Fosse Green Energy

EN010154

8.10 Statement of Common Ground with National Highways

24 March 2026

**TYPICAL TRENCHLESS CROSSING PLAN VIEW**

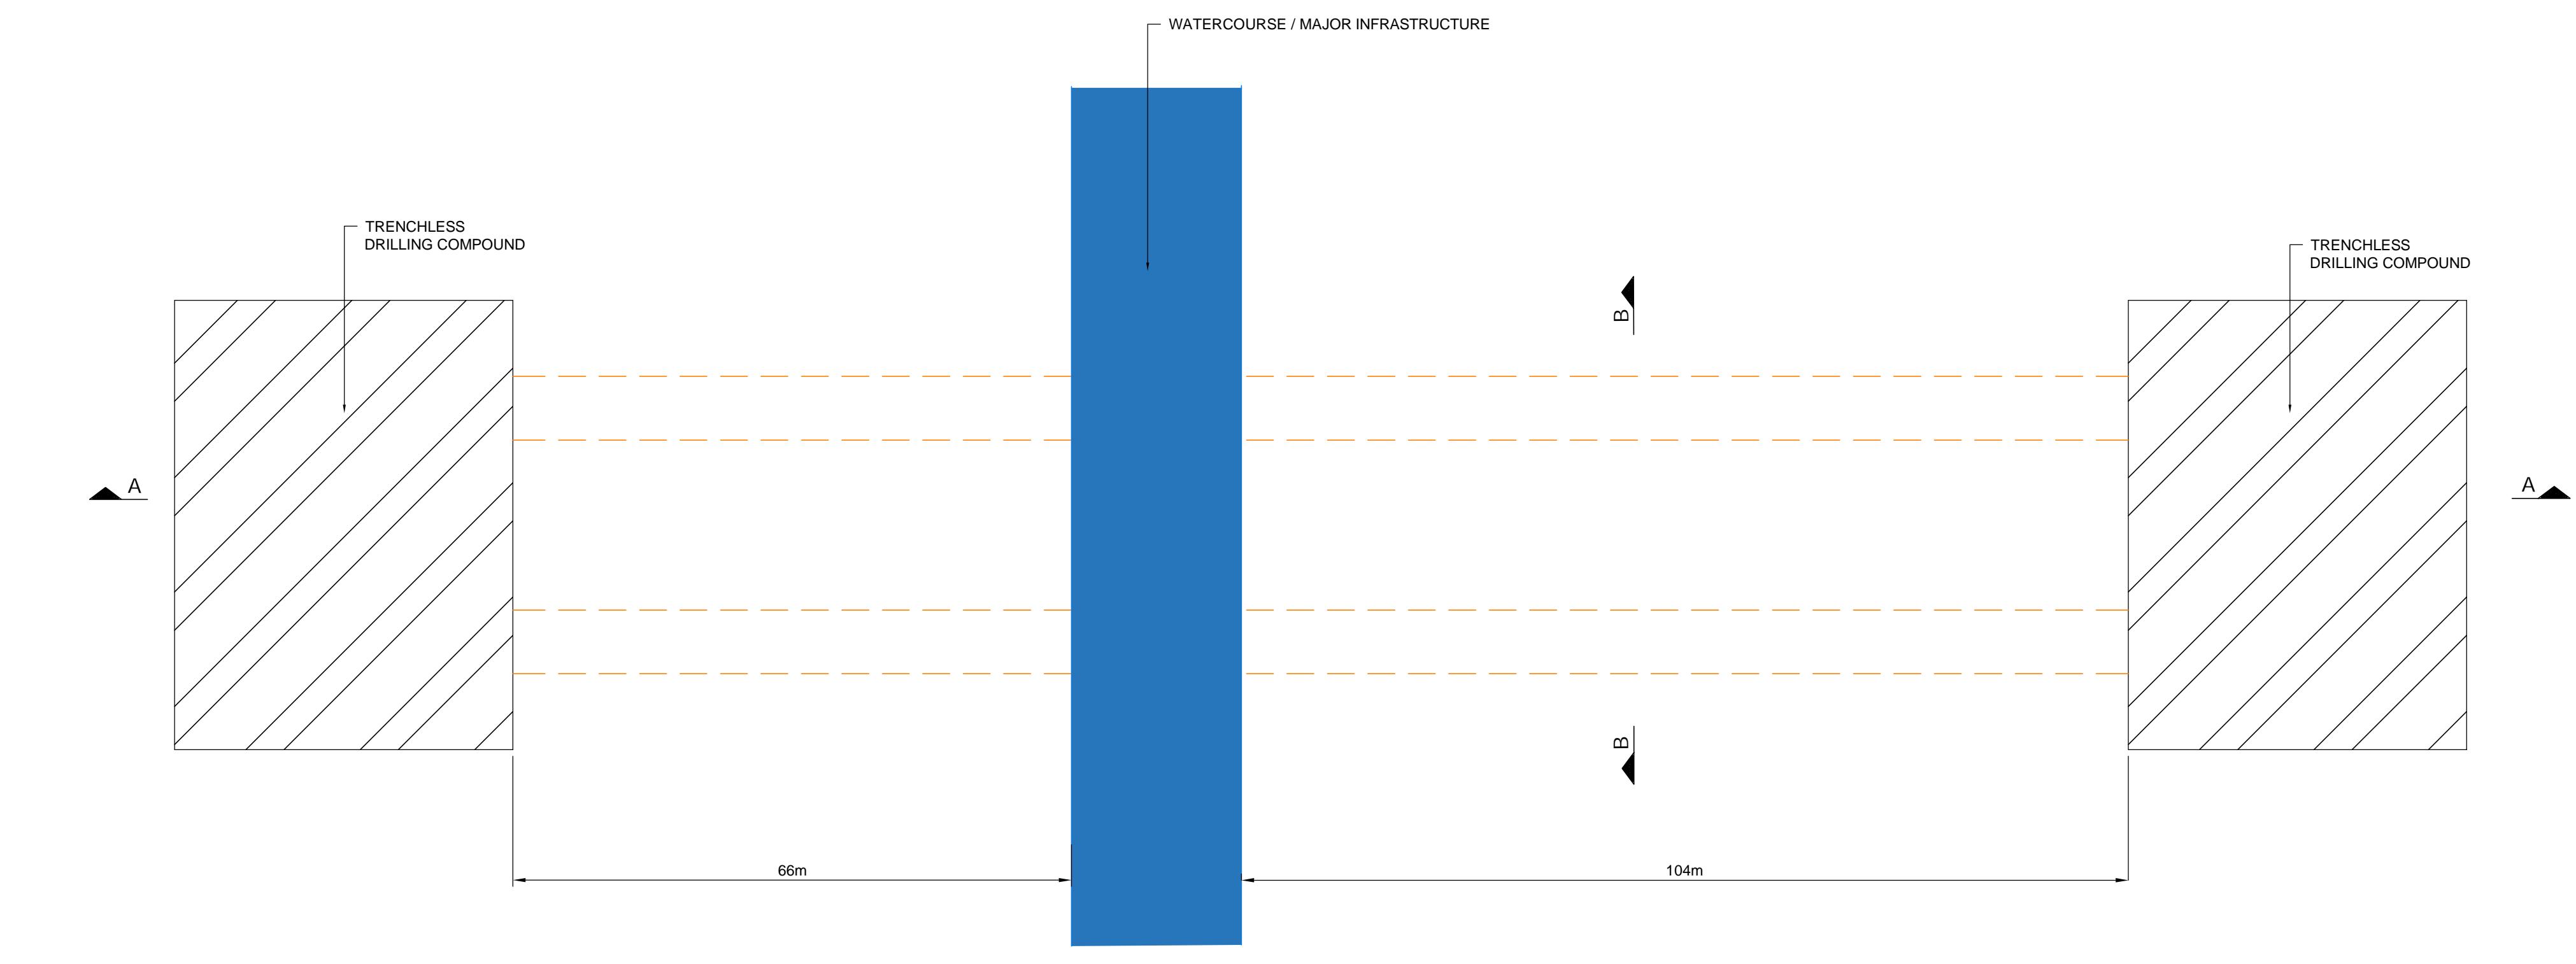
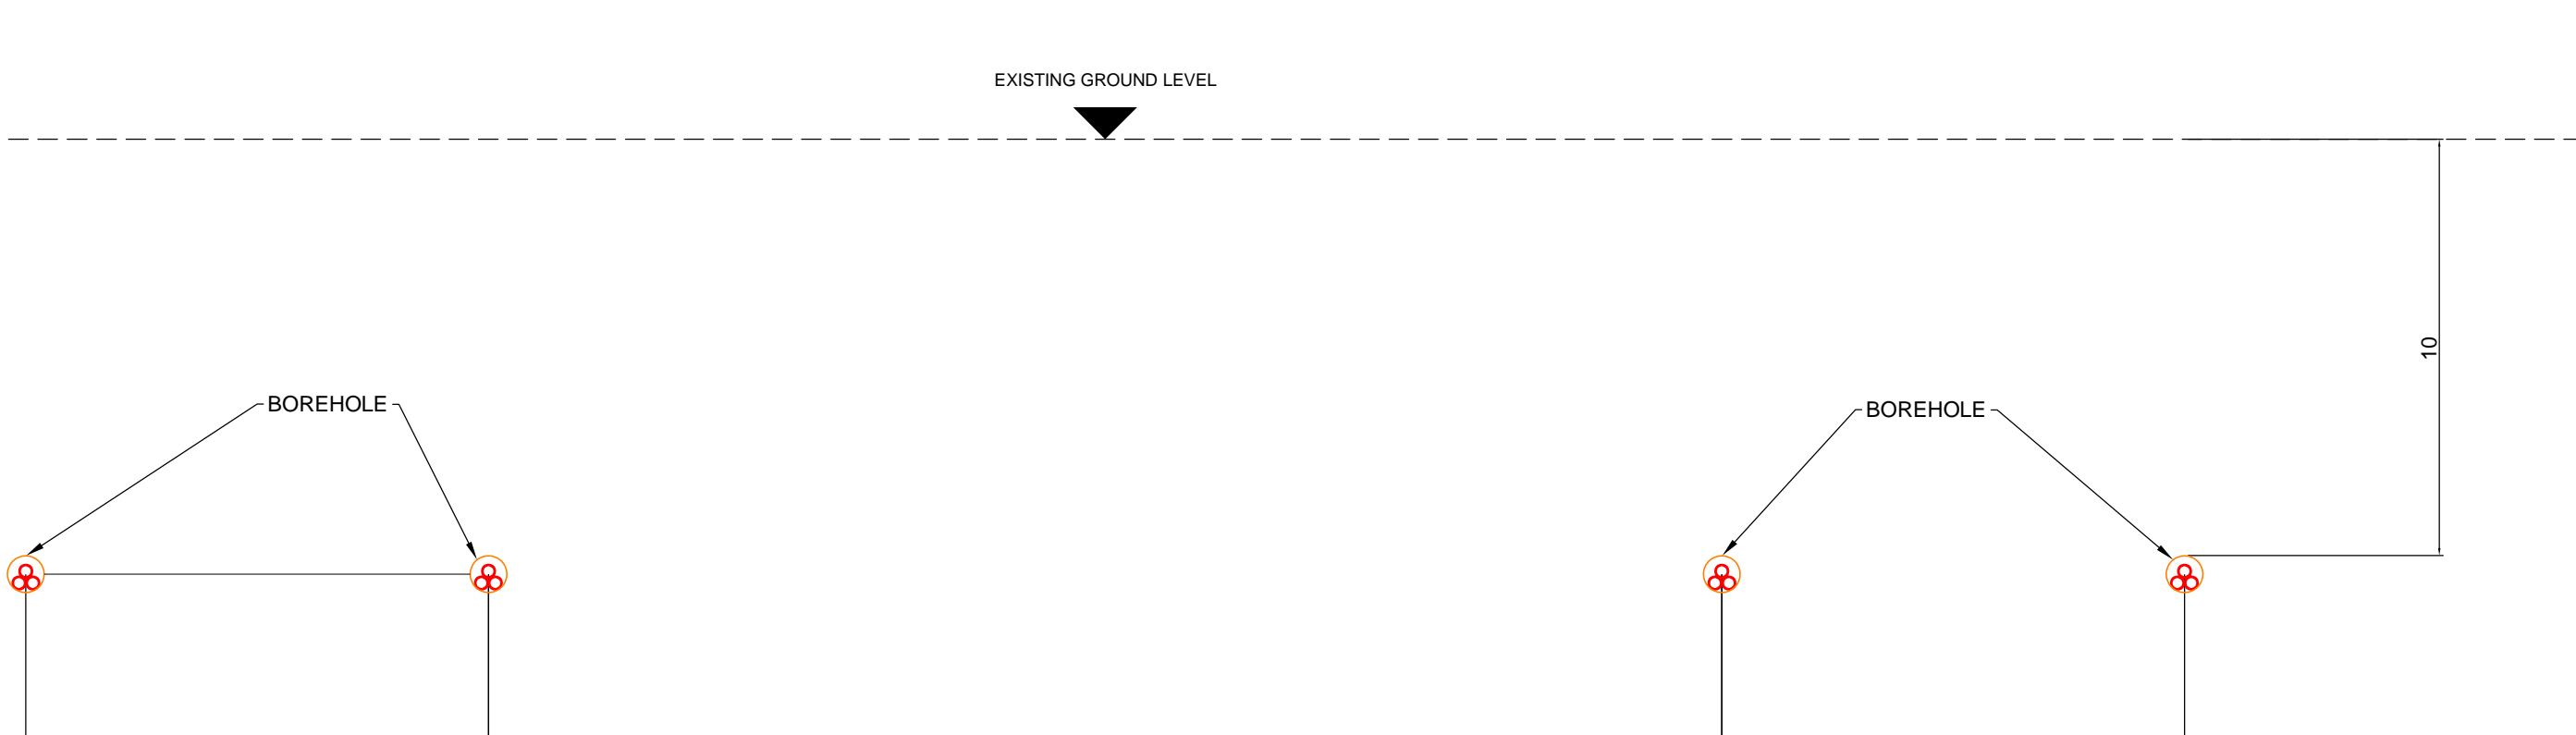
4.3.2	Geotechnical Risks on A46 Trunk Road	<p>The cross-section information provided on ES Figure 3-13 Typical Trenchless Crossings Cross Sections [APP-060] is insufficient to determine the geotechnical risks on the A46 trunk road. Any proposed directional drilling under our network will require compliance with The Design Manual for Roads and Bridges (DMRB) Chapter CD622 (Managing Geotechnical Risk).</p> <p>This issue relates to geotechnical risk (as noted above) and is subject to further discussion when the proposed cable route</p>	<p>It should be noted that a design has been submitted as part of the DCO Application which incorporates spatial flexibility within the Proposed Development Parameters [REP1-029] to account for any localised constraints which may be identified later in the process. As such, the purpose of Figure 3-13: Typical Trenchless Crossings Cross Sections of the ES [APP-060] is not to demonstrate the specific geotechnical risks on the A46 trunk road at specific crossing locations since these could vary from location to location.</p>	Under Discussion

Reference	Description of Matter	National Highways Position	Applicant Position	Status
		<p>location is fixed during the detailed design stage. From NH's perspective, it's important for us to be kept informed and able to review/accept proposals in accordance with DMRB CD 622 requirements. This is proposed to be safeguarded through the ongoing Protected Provisions which are under discussion.</p>	<p>The geotechnical risks will be established as part of the detailed design stage once final locations of the trenchless crossing locations are known, aligning with other potential factors that may influence the detailed design (e.g. avoiding archaeological resource). The Applicant will comply with DMRB Chapter CD622, and other relevant requirements for any proposed directional drilling under the SRN.</p> <p>The NH Protective Provisions to be included in the draft DCO [REP2-005] at Deadline 3A of the Examination make specific provision to secure compliance with the DMRB CD 622 requirements.</p>
